**ADC Planning Consultation
Response from the Historic Buildings Adviser**

Application Number	A/103/15/L
Address	Saddlers, High Street, Angmering
Description	Application for Listed Building Consent for new lime render coating to flank wall.
Case Officer	Anita Gardner
Site Visit

EXISTING SIDE ELEVATION

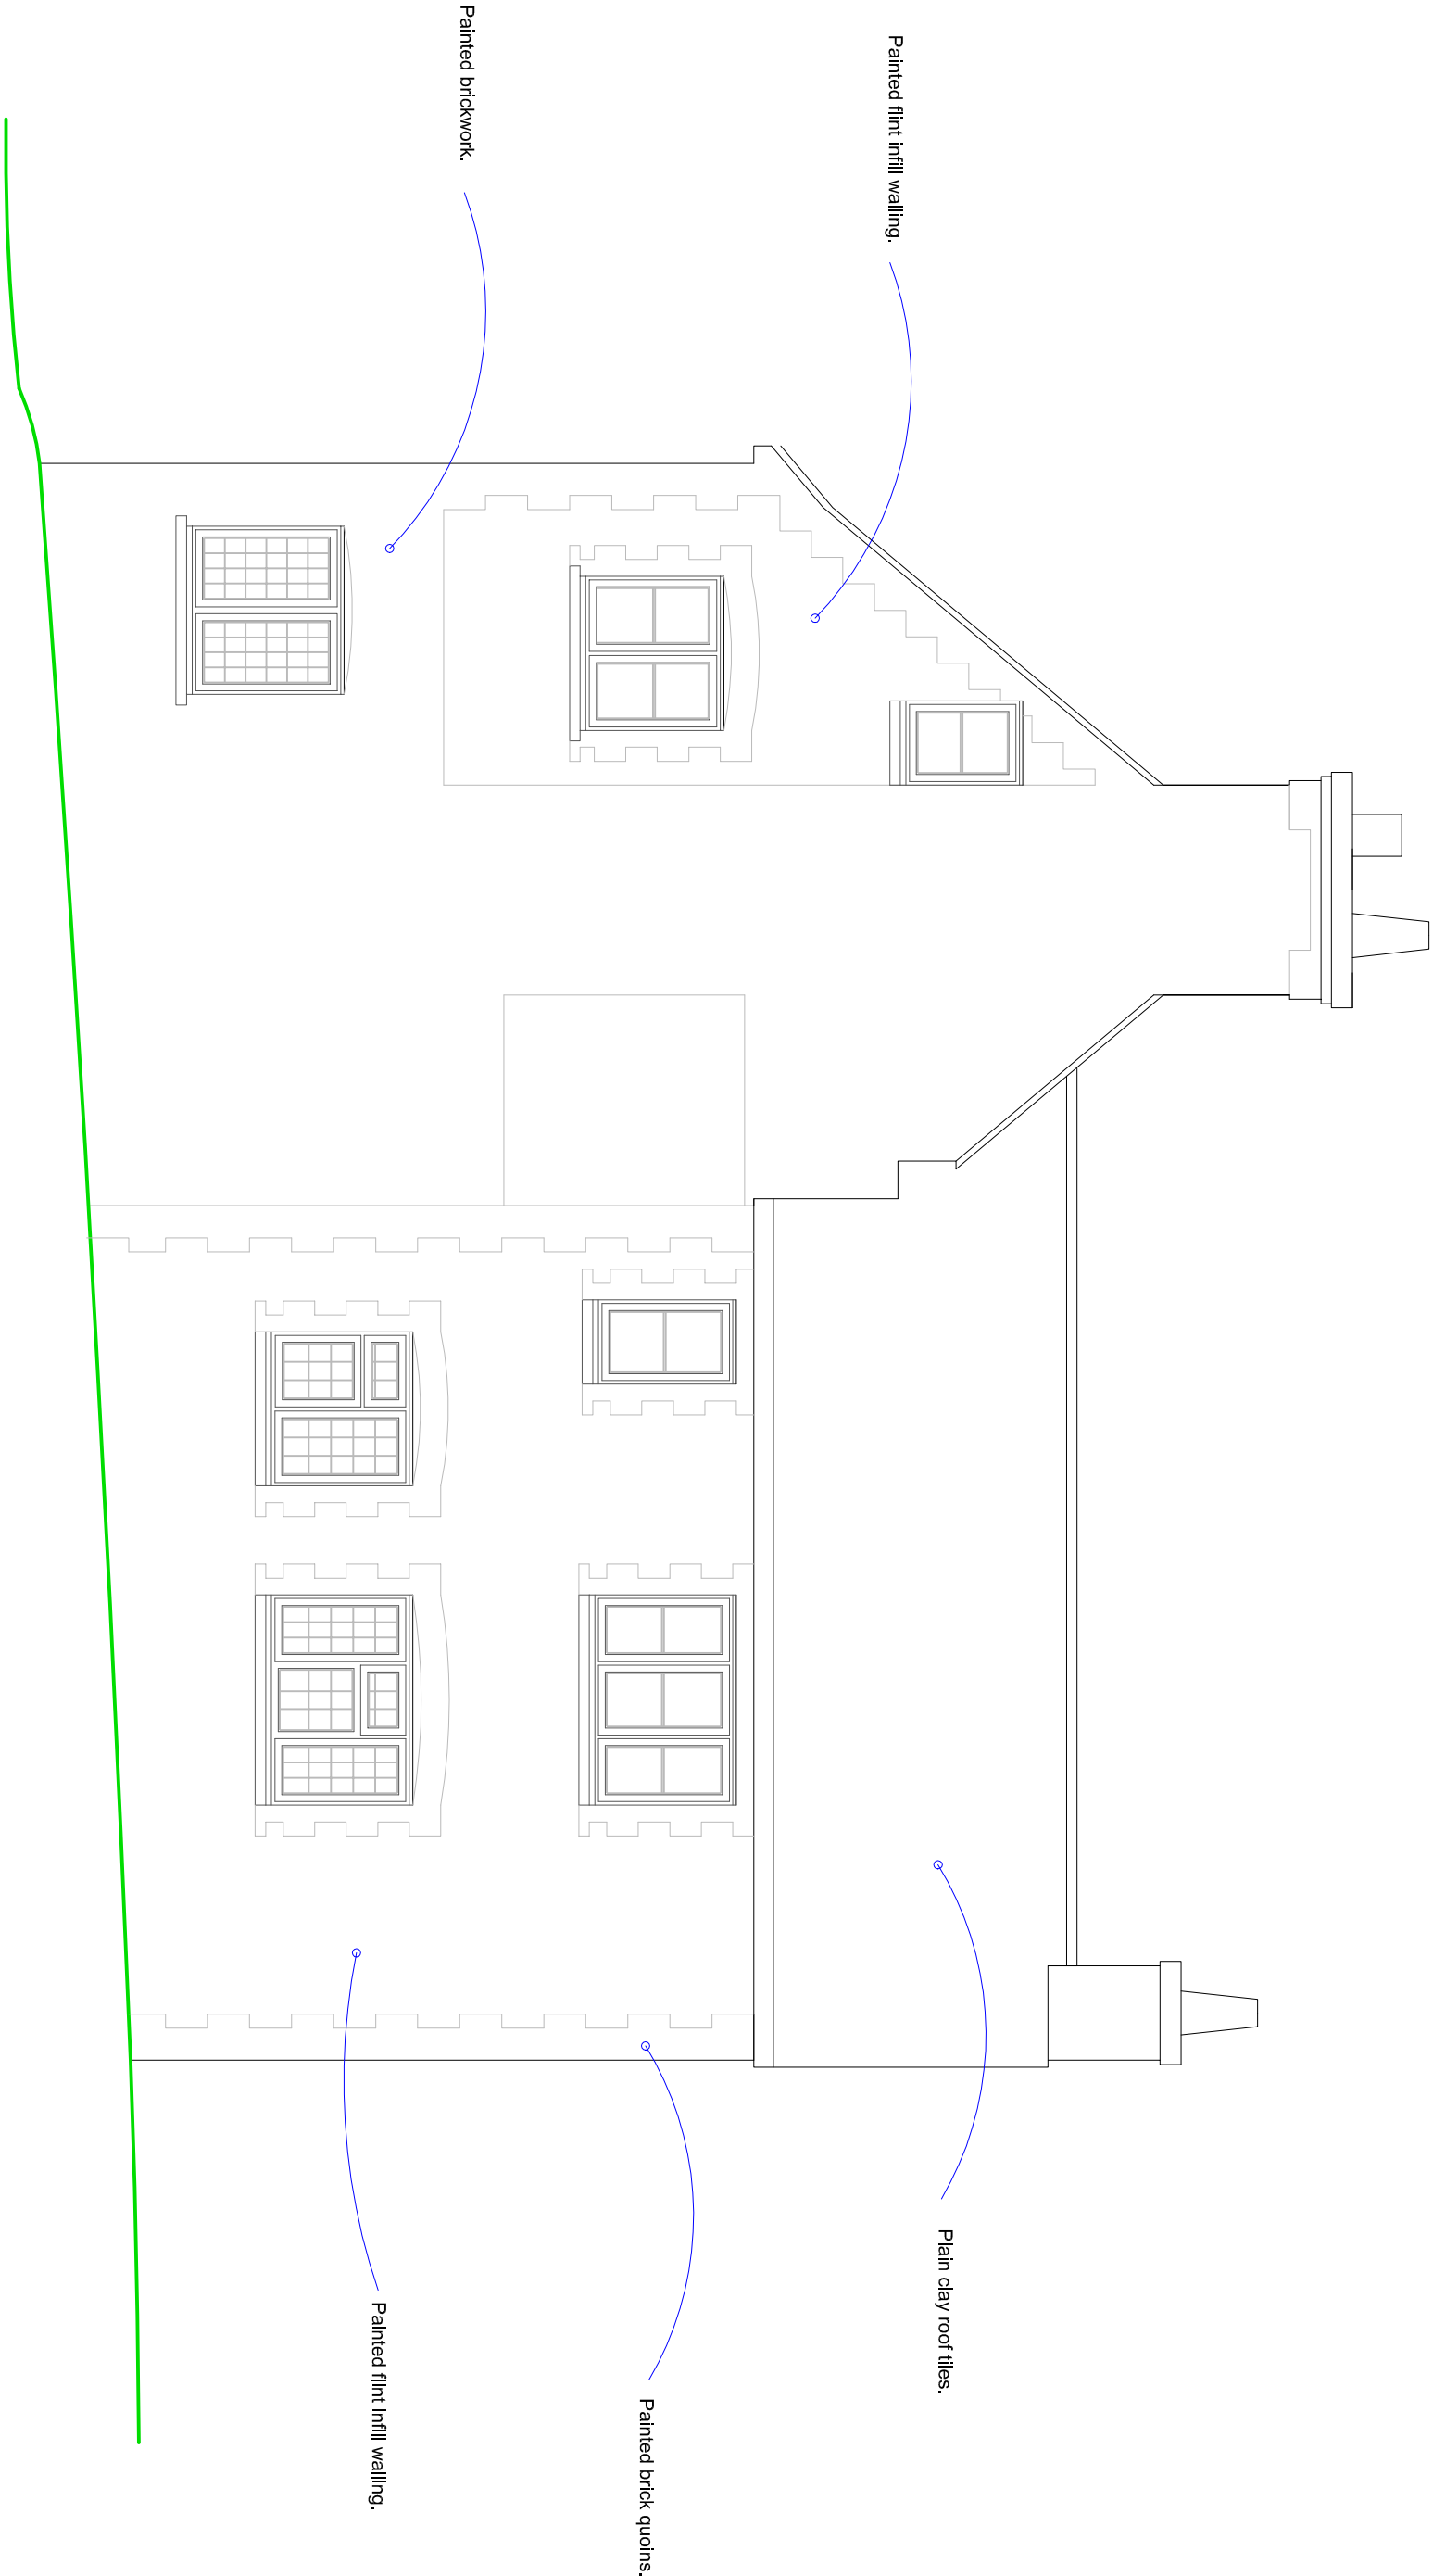
Solid wall construction requires permeability throughout for the walls to breathe and moisture to move from the inside-out. Removal of the external paint may therefore be essential if this is not permeable because it could be trapping moisture within the substrate and contributing to the problem. It could also be disguising later cement pointing which again could be a contributor.

PROPOSED SIDE ELEVATION

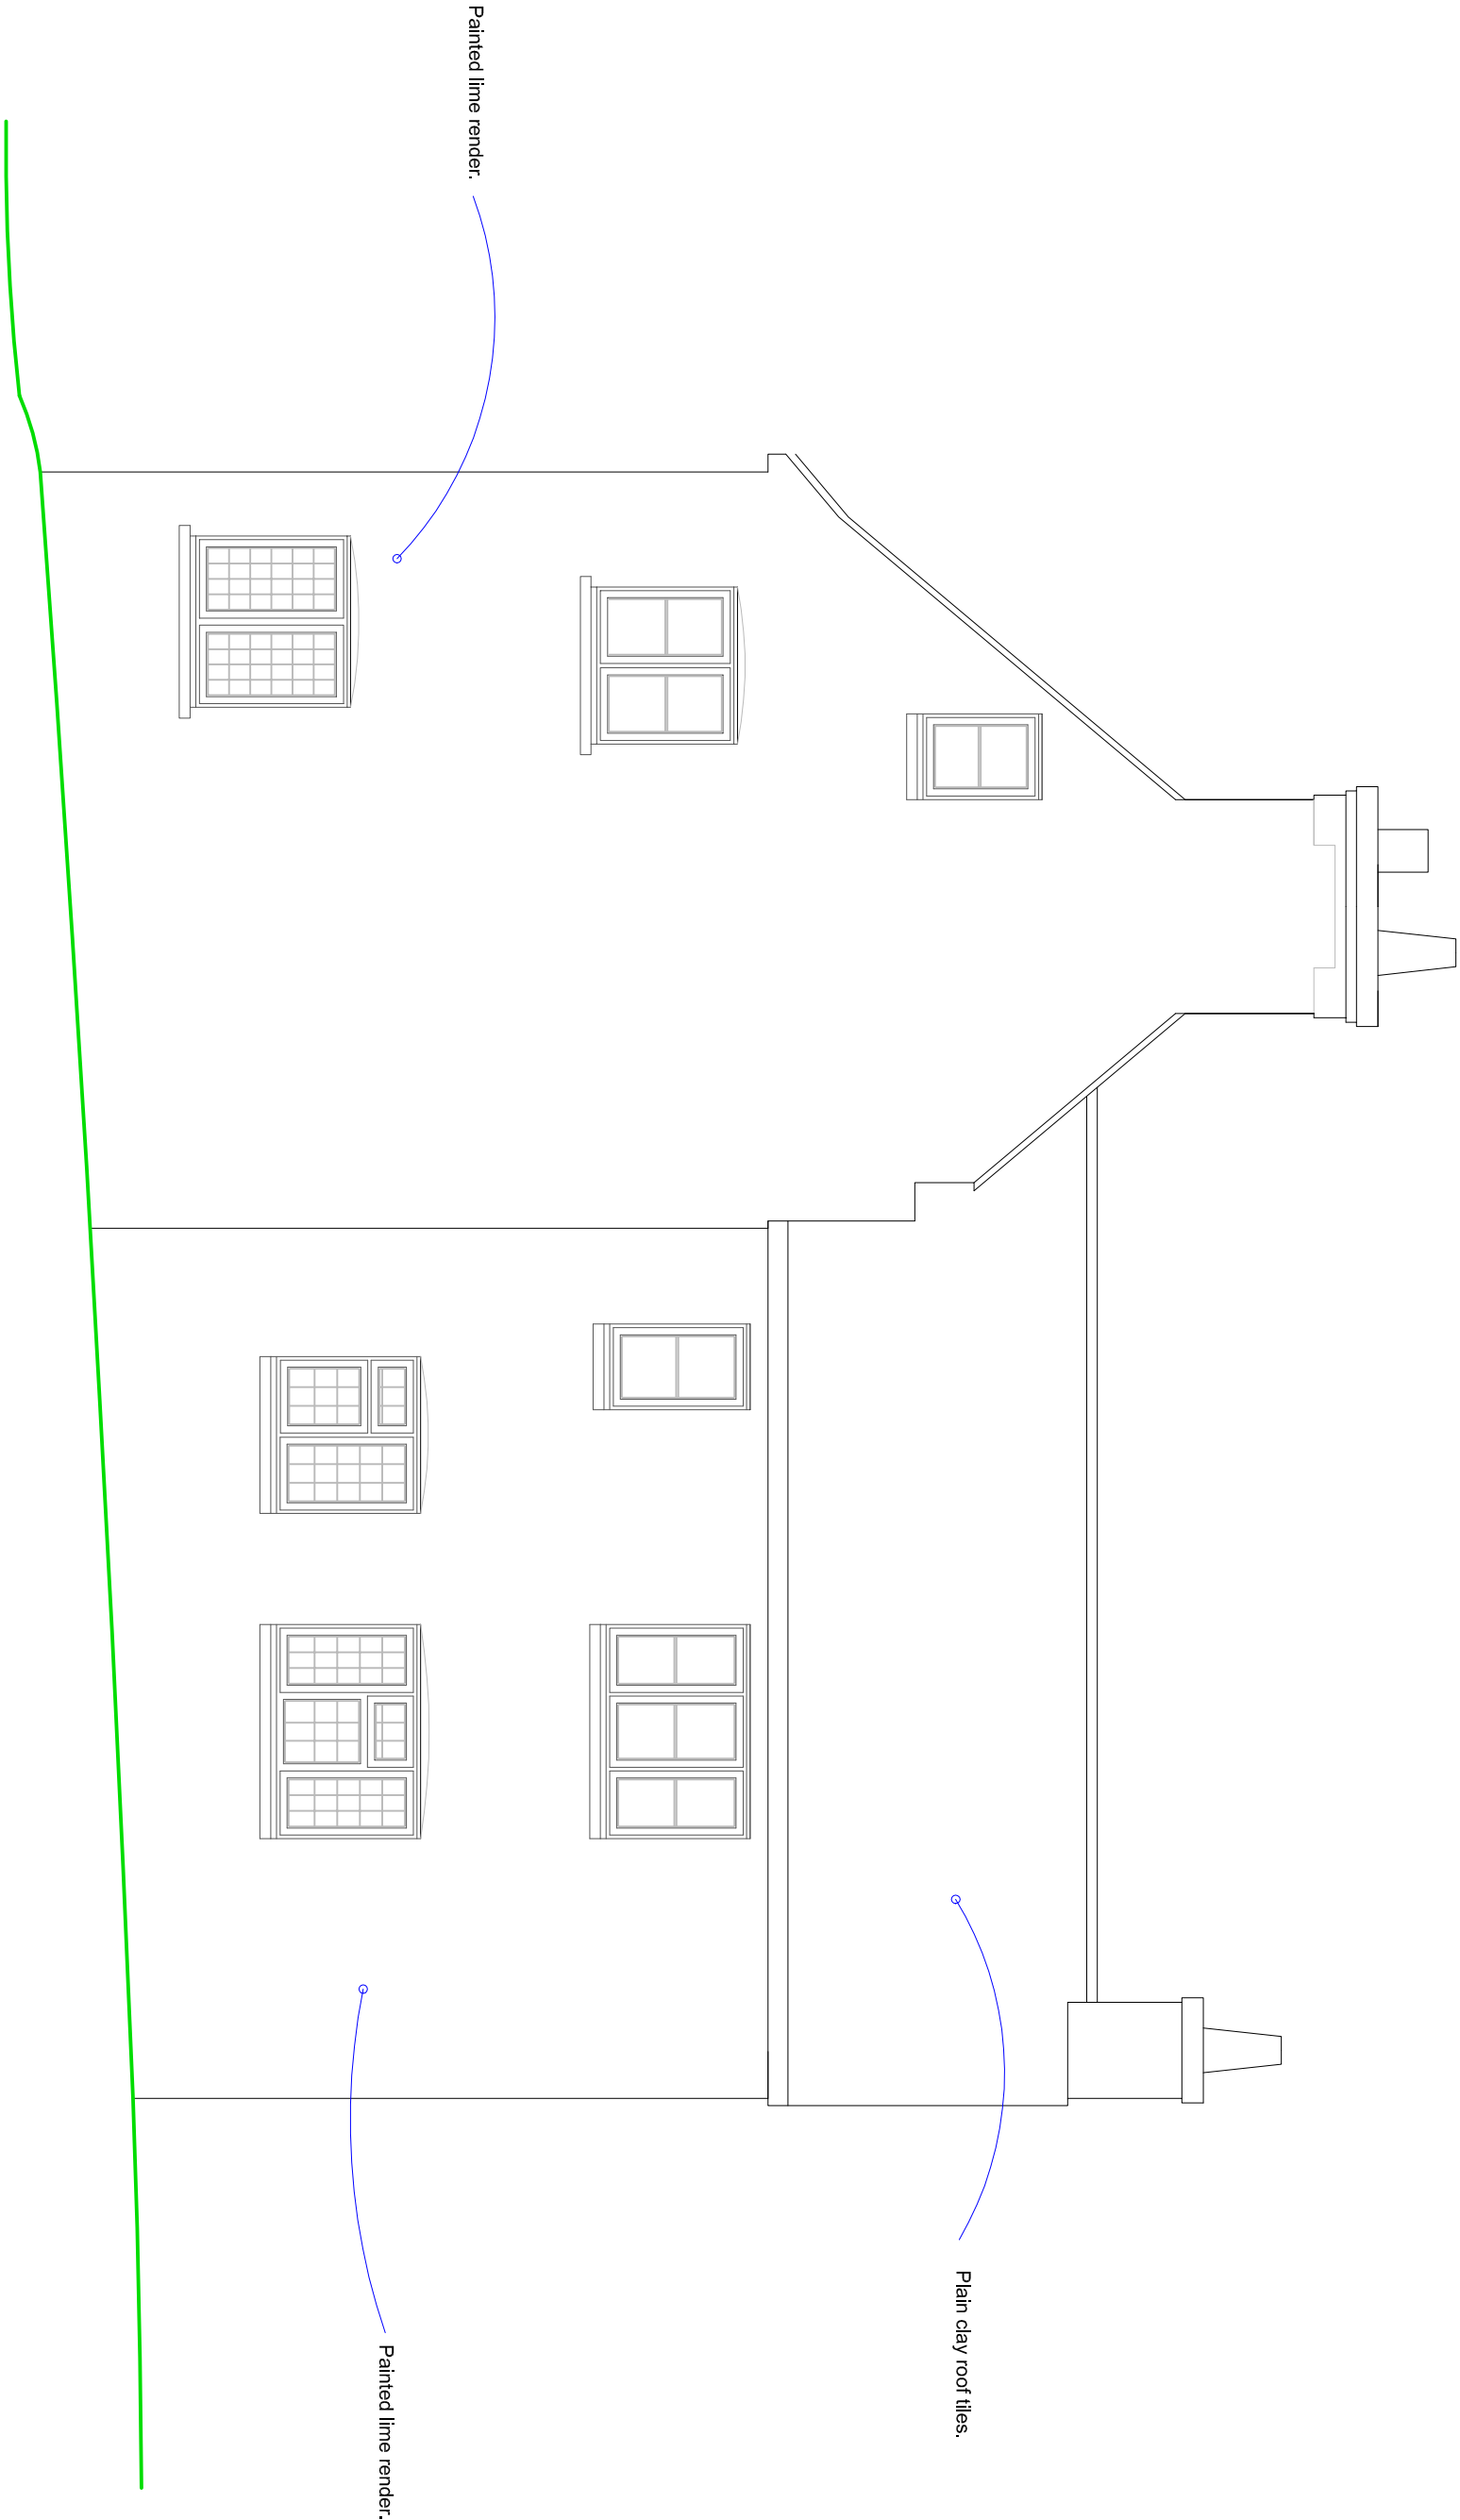
Whilst there is no objection to the principle of rendering, the following points should be noted:

This will not be known until the paint is removed however the replacement of cement should be factored in to the works where this exists.

Similarly, the internal walls could also be causing issues if a modern internal plaster has been used instead of lime. This will similarly trap moisture until areas become wet. If this is occurring at ground floor level, further contributors could be concrete floor slabs (where they exist) and external hard ground surfacing which can trap moisture within the ground and force it into the walls.

- Method statement for the removal of paint. (This should be of conservation standard.)
- Details of any new paint or wash to be applied over render. This must be breathable to allow moisture out.
- Method statement for the removal of cement pointing should it be found. This will need to be done by hand and not with machine tools.
